July 29, 2015

Mr. Travis Saunders, Senior Planner  
Development Service Group  
City of Mercer Island  
9611 SE 36<sup>th</sup> Street  
Mercer Island, WA 98040

**RE: Review of 5637 Mercer Way – Revised Critical Areas Report**

PORTION OF GOVERNMENT LOT 3, OF SECTION 19, TOWNSHIP 24 NORTH, RANGE 5 EAST, W.M., KING COUNTY, WASHINGTON

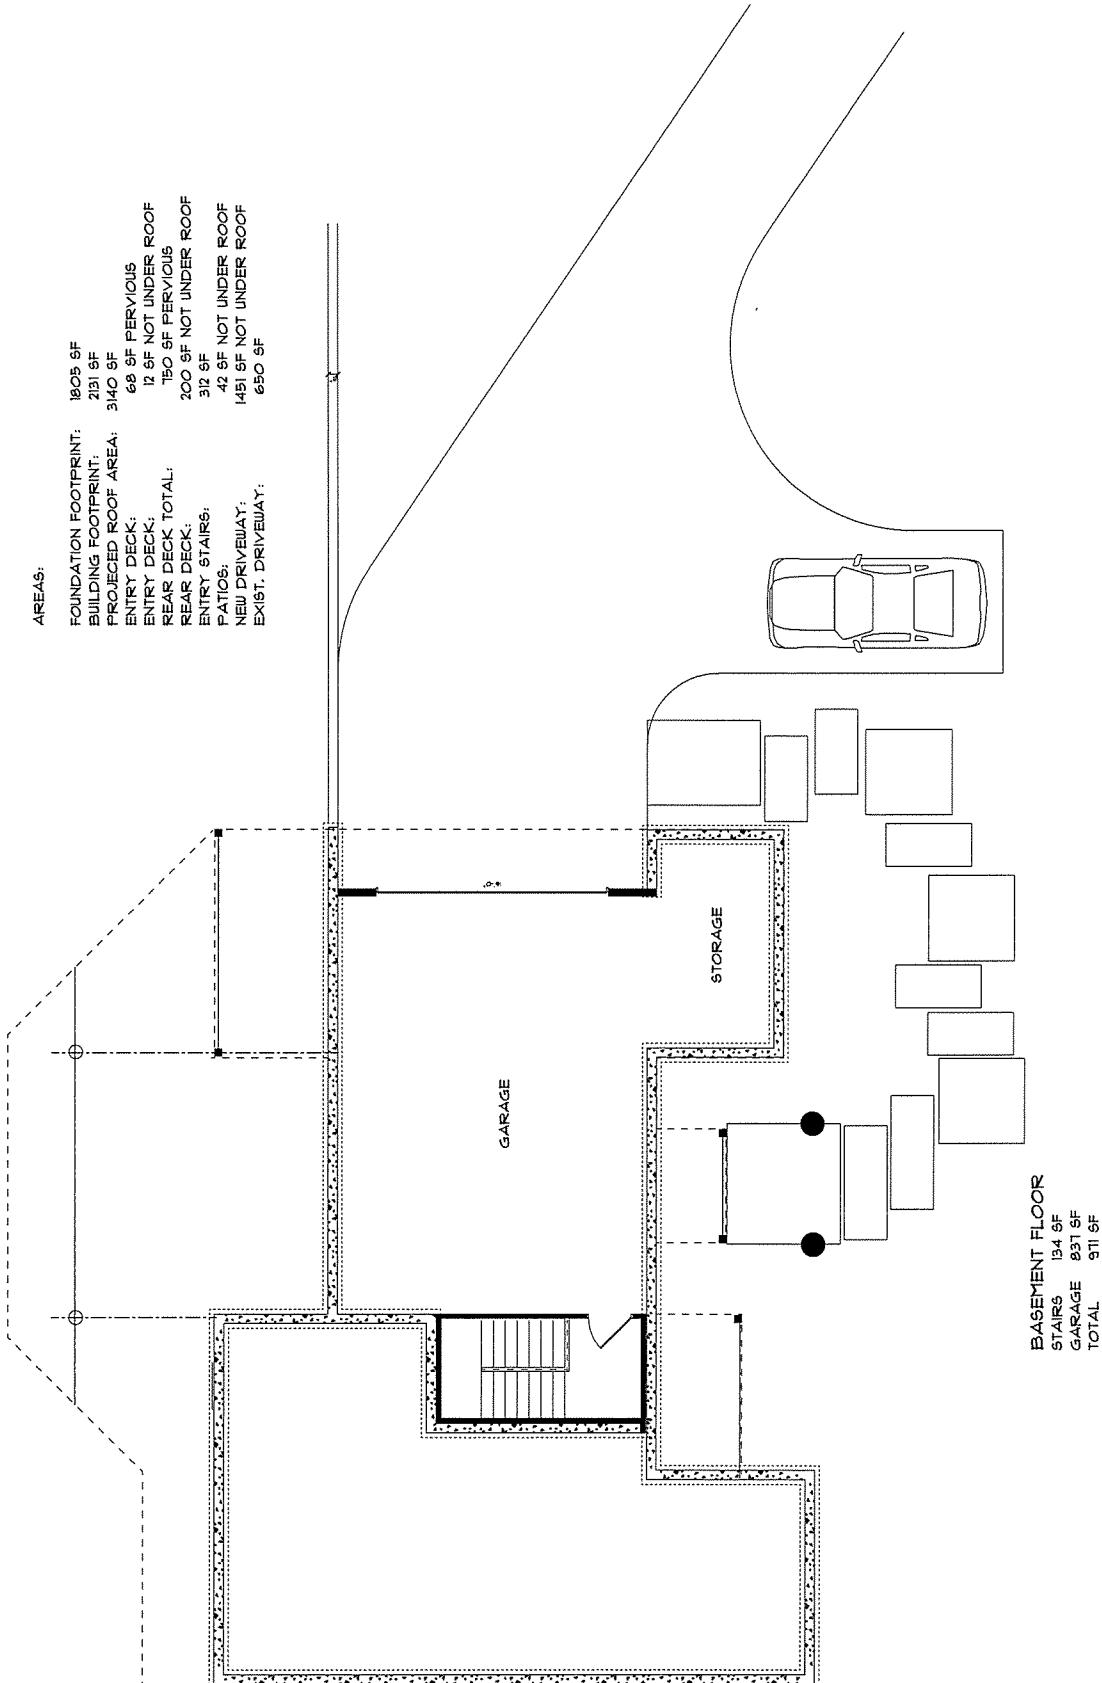
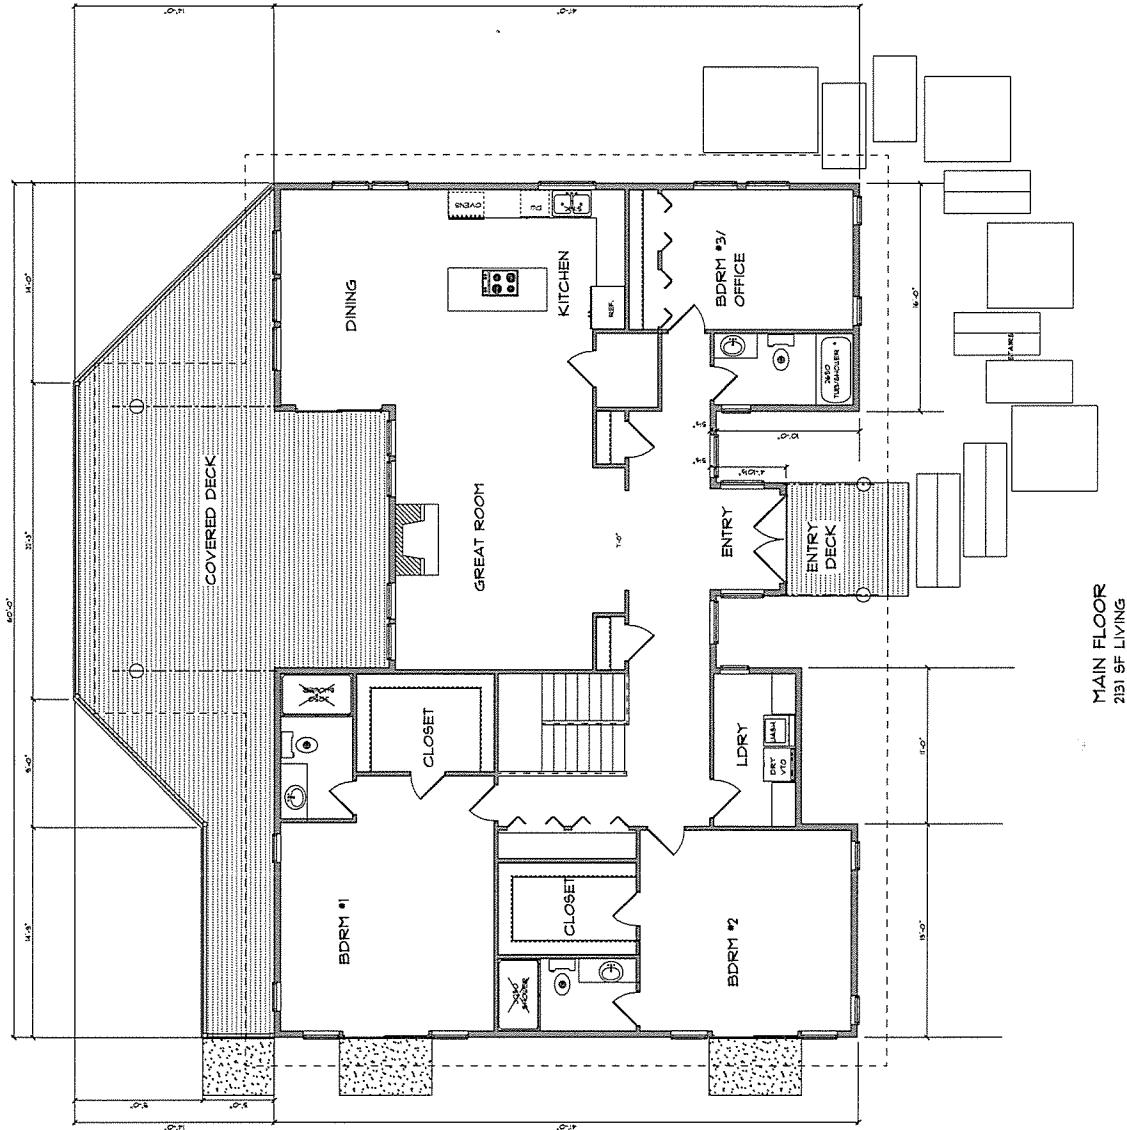
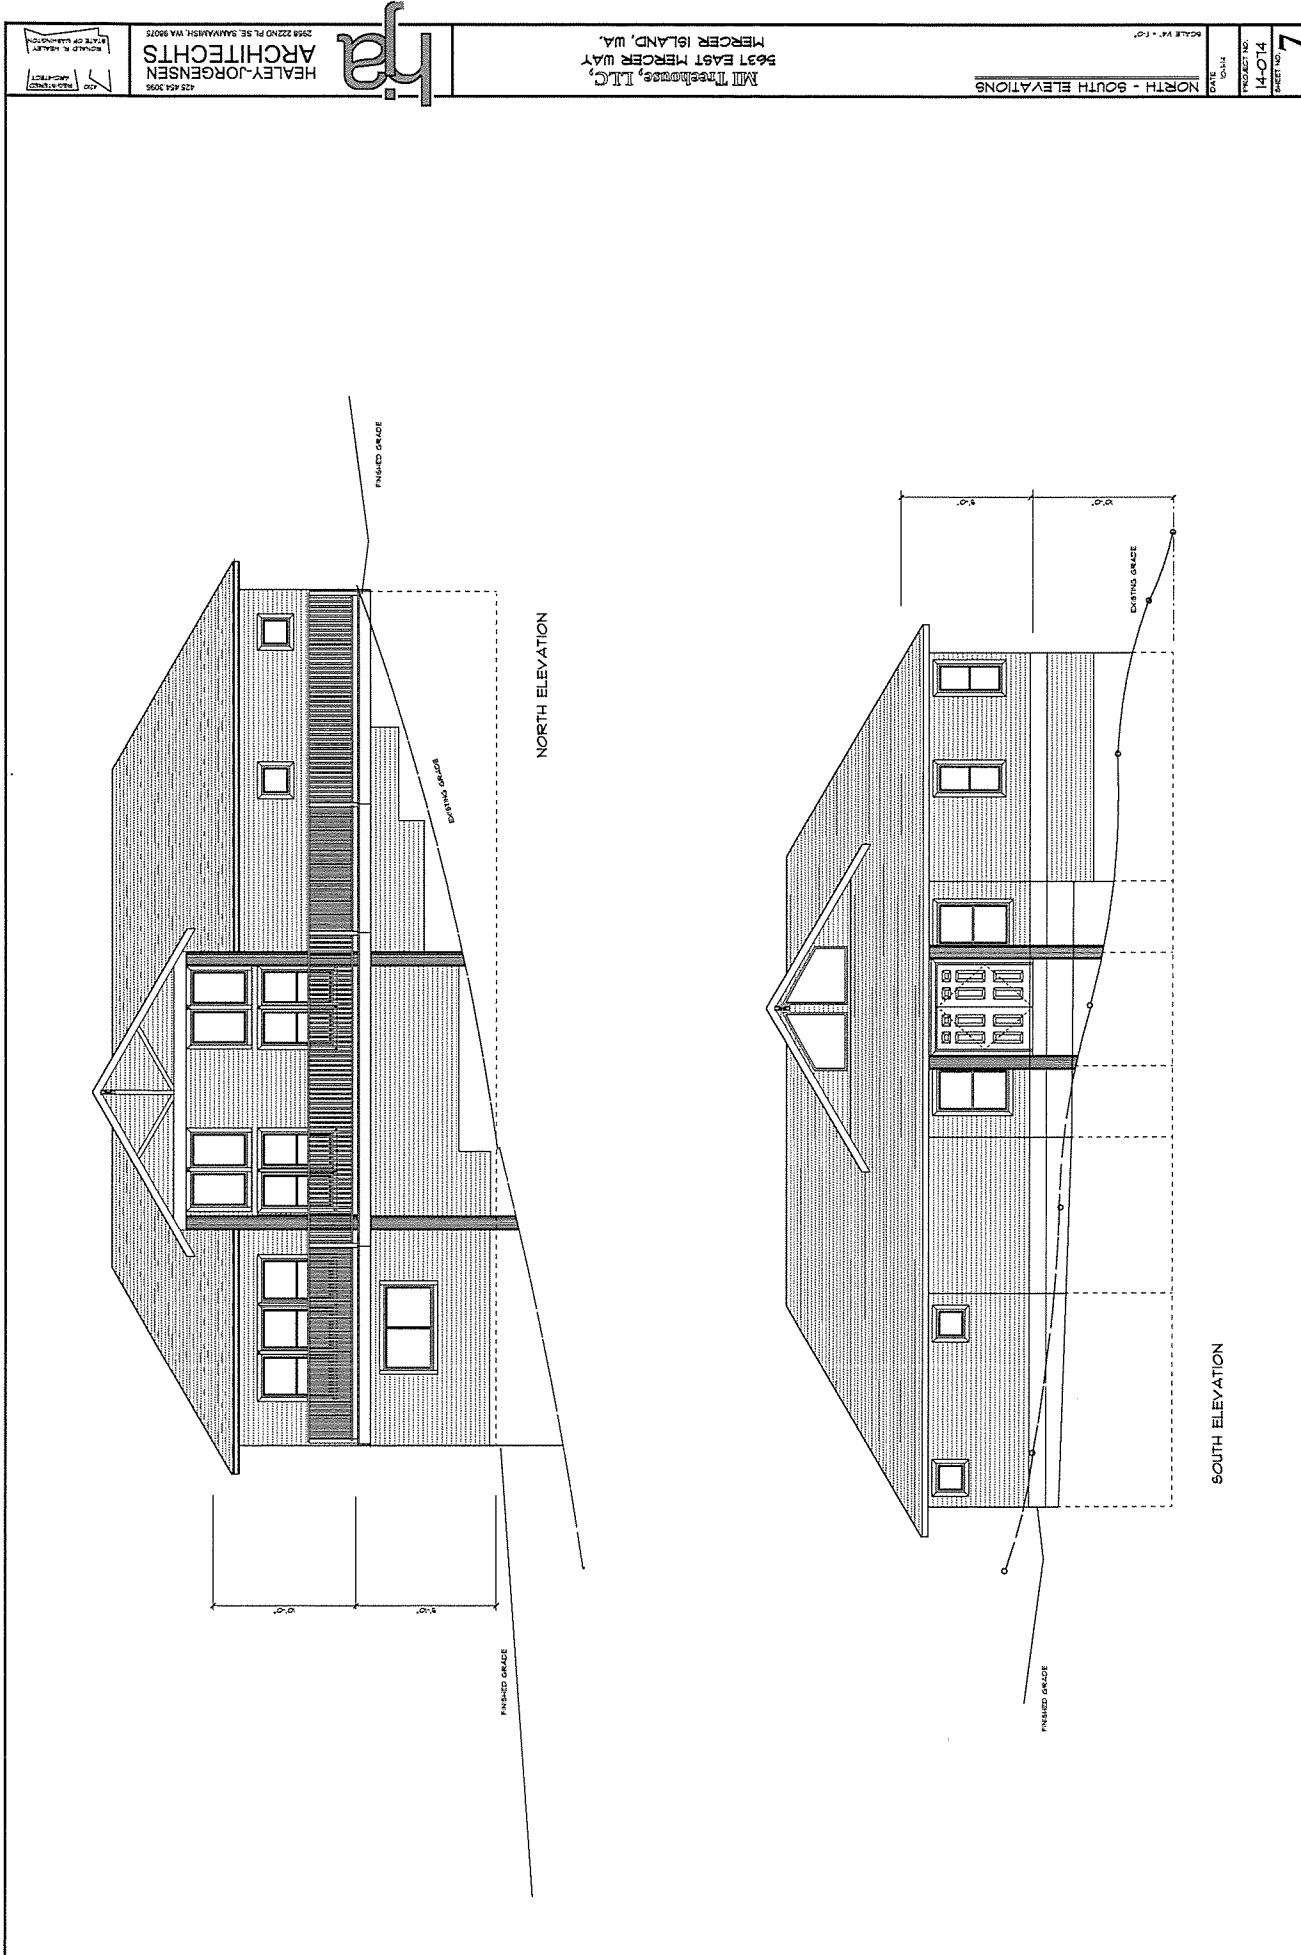
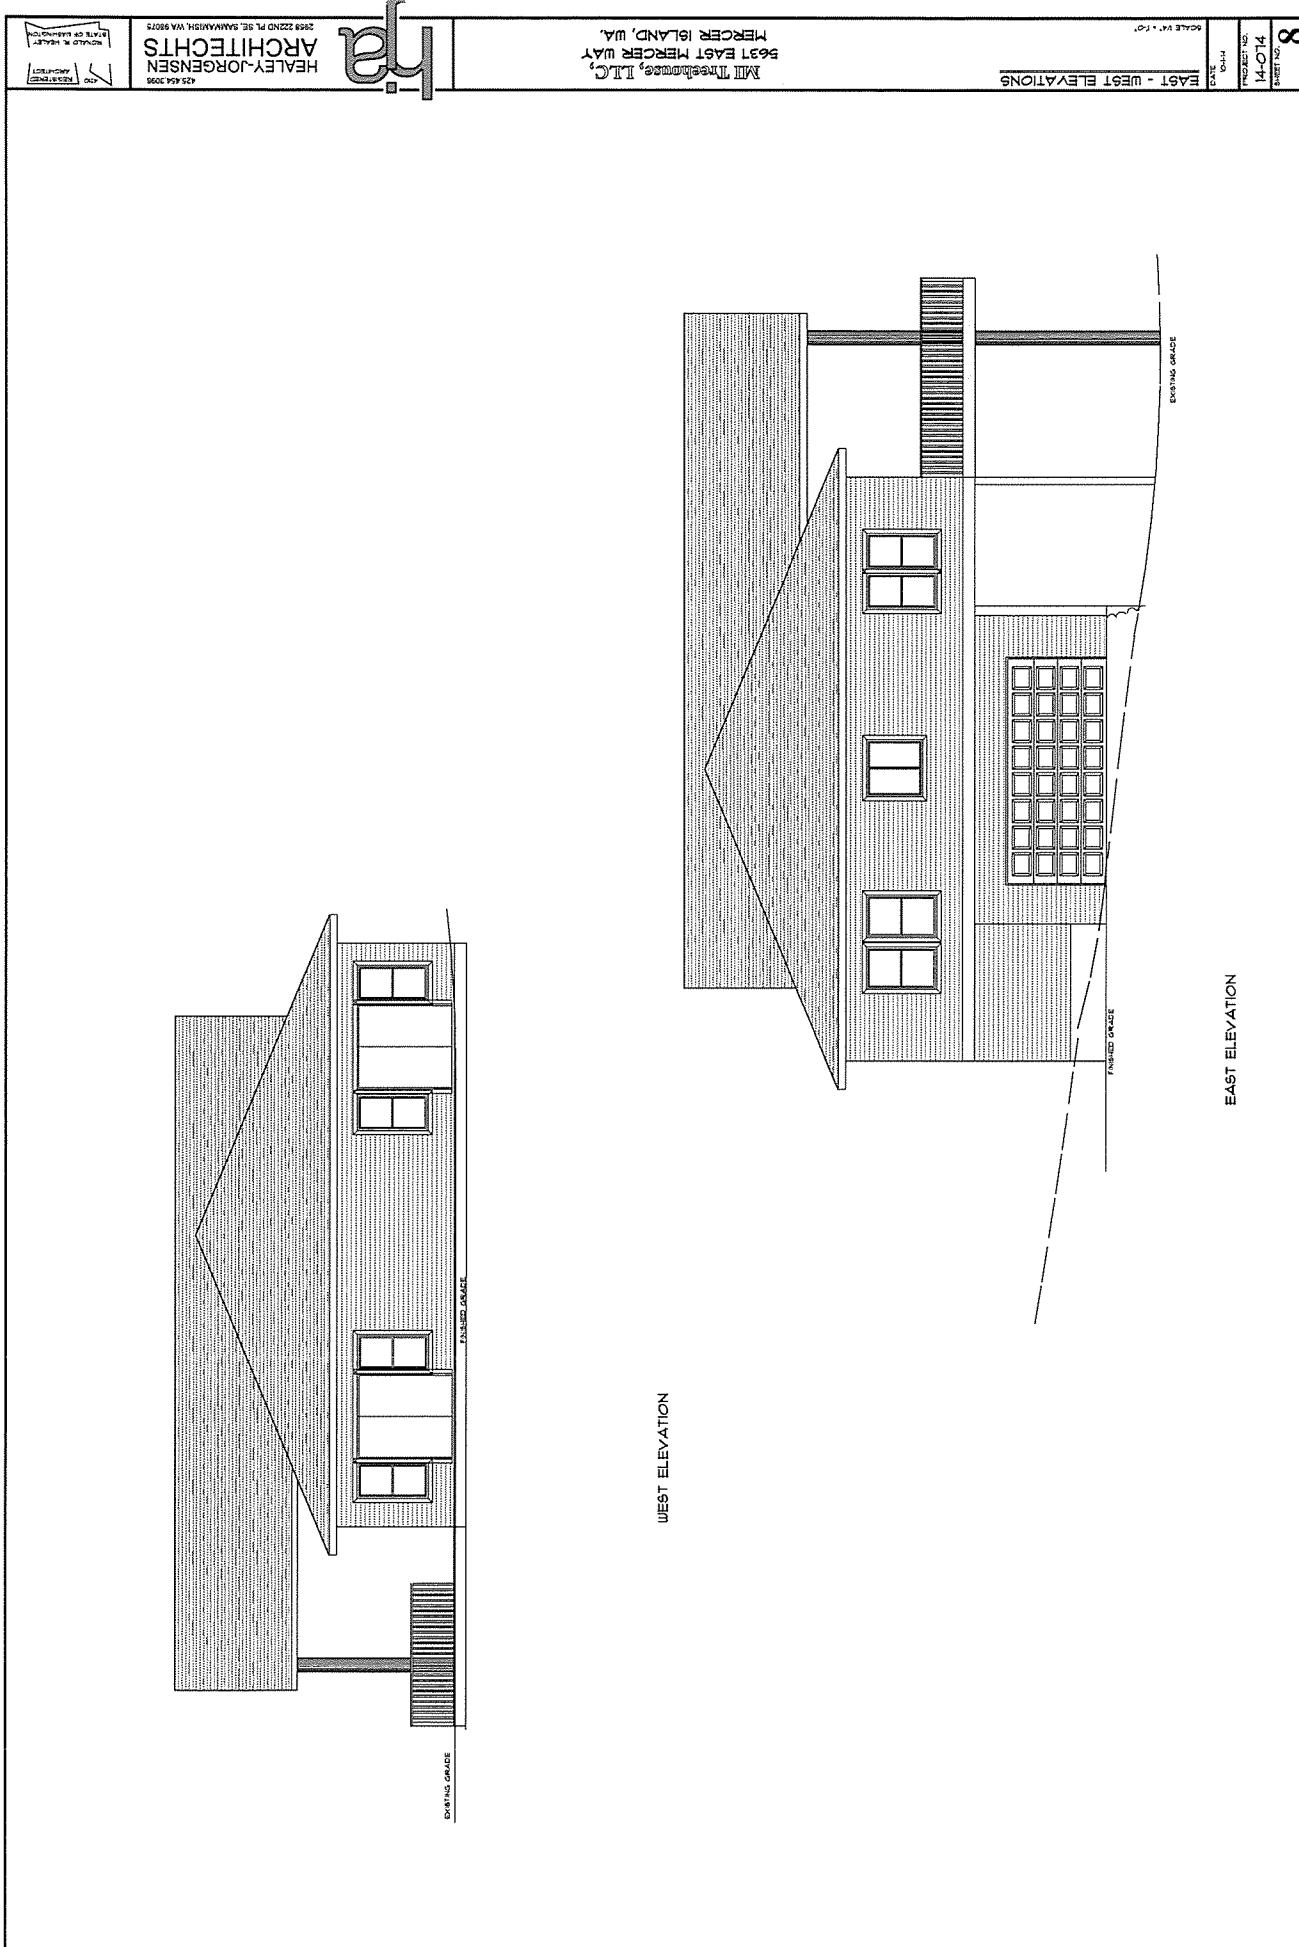
During our June 8 site review, we walked the site in proximity to the proposed house location and reviewed the extent of wetland area and stream location. The wetland boundary depicted in the submitted critical areas enhancement plan, Sheet 1 of 1, appears to generally reflect field conditions; however, surveyed wetland boundary points were not identified in the field, so this determination is based on comparison with this figure. A small discrepancy was noted in the field where there appears to be a relatively small upland area measuring several hundred square feet located upslope of gabion wall on the eastern portion of the parcel. Elsewhere on the site, the wetland boundary is largely dictated by site topography. We did not review wetland boundaries at the western/northwestern portions of the property, but did conduct a quick reconnaissance of this area to determine the appropriateness of wetland enhancement actions. These areas appear to contain wetland associated plants and are dominated by native species, making enhancement of this area, aside from under-planting with native coniferous species, a mitigation action that would not provide significant functional lift.

In addition to the Type 2 stream previously identified by Sewall, an additional stream was observed south of and flowing approximately parallel to the originally identified stream. This new stream likely contains perennial flow, but does not support fish. The stream is located in a topographical depression, had a bank full width of approximately 4 feet, a wetted width of about 1-foot, and roughly 1-inch of flow. Hydrology to the stream is likely provided by outflow from Wetland A, as the channel originates in the central portion of the parcel based on topography as mapped on the critical areas enhancement plan figure, Sheet 1 of 1.

The mitigation plan submitted as part of the CAR indicates the originally identified Type 2 stream flows to the west; however, it was observed to flow east during the field review; this should be corrected.

- Stream and/or stream buffer impacts should be accounted for in the CAR and appropriate compensatory mitigation should be implemented.
- The critical areas enhancement plan figure, Sheet 1 of 1, should indicate the stream flows to the east.

- Fallen trees should be retained onsite and placed within the buffer of the streams.
- The dirt trail on the northern parcel boundary should be surveyed and identified on appropriate project plans and the mitigation plan.
